Application No: R/60/22/PL
Site Address: The Windmill Inn Mill Lane Rustington BN16 3JN
Description of works: Extension and remodelling of existing public house to form hotel with 20 No bedrooms and associated parking and landscaping. This site is in CIL Zone 4 (Zero Rated) as other development.

Thank you for your internet representation made on 25th April 2022 which has been recorded as an objection with the comments as follows:

Drawing No.	2021-6377-001	Rev.	B
-------------	---------------	------	---

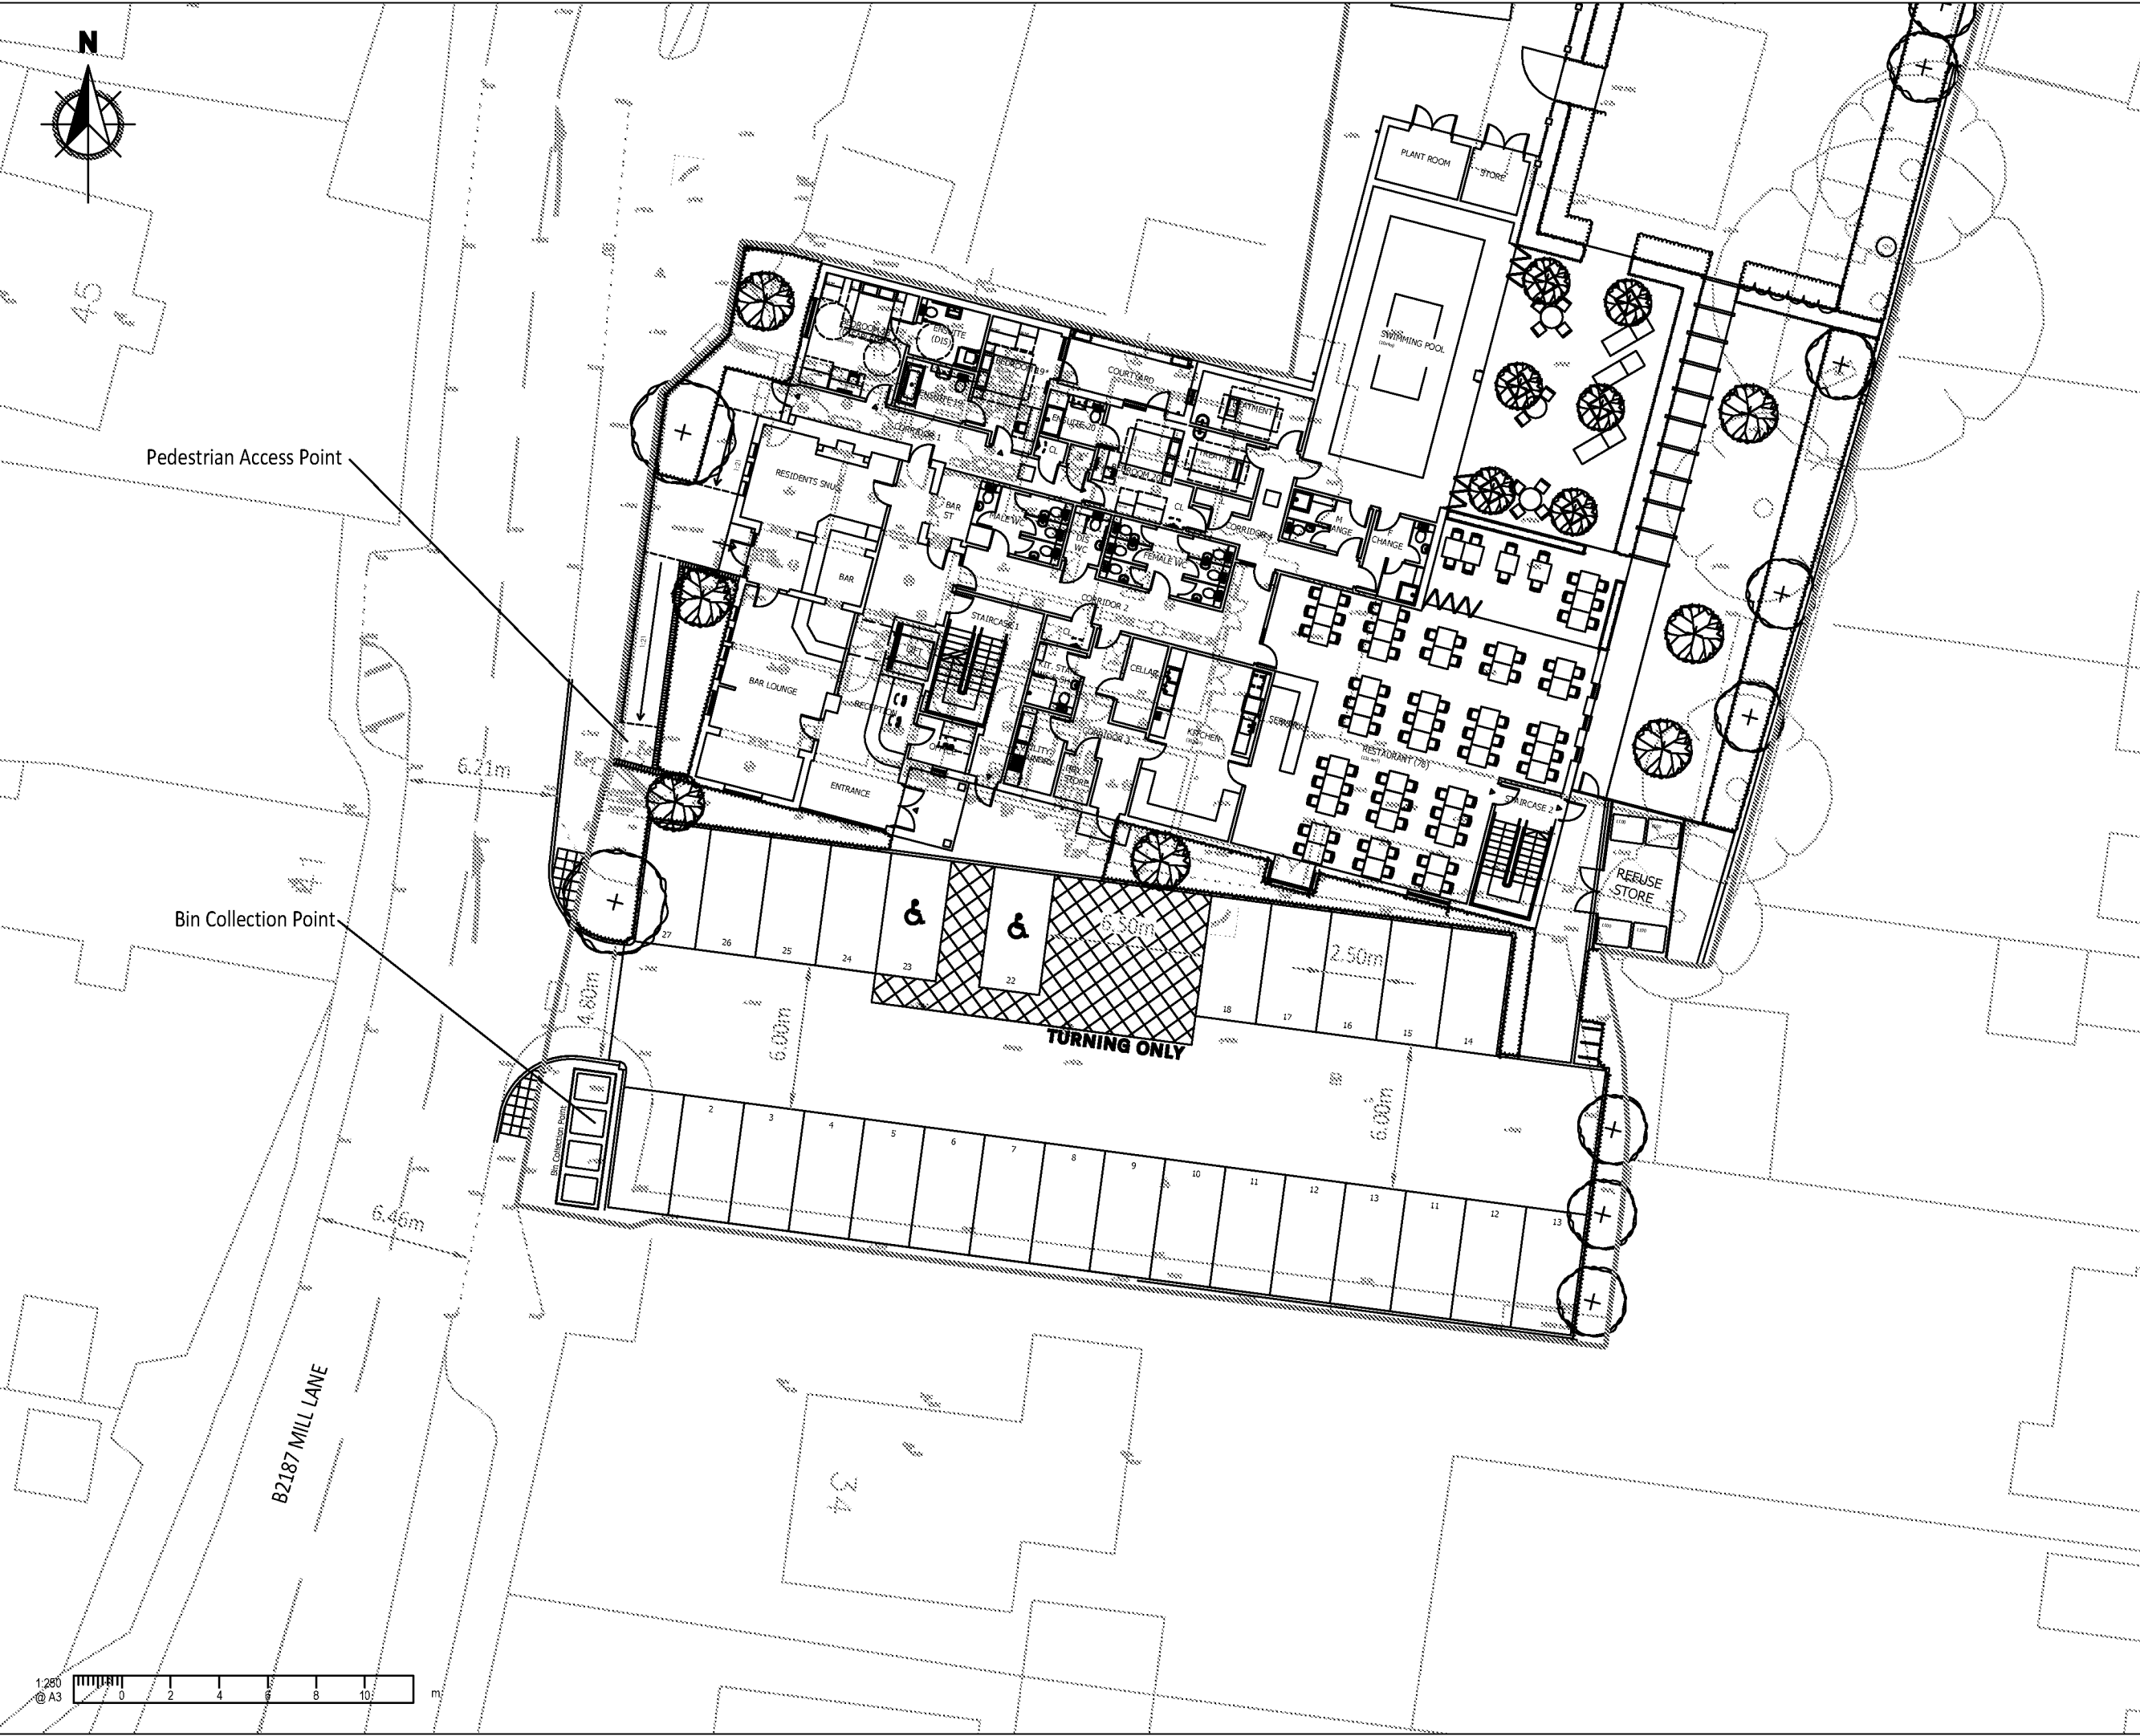
Arun parking standards state A3 Restaurant and Caf 1 space per 5sqm of public area and 2 spaces per bar (or 5m length of bar for large bars) for staff parking to be clearly designated 1 space per 4 staff to be clearly designated and 1 space per 25sqm for customers. WSCC parking requirements C1 also states 1 parking space per bedroom for the hotel 20 spaces. These numbers just do not add up to 27.
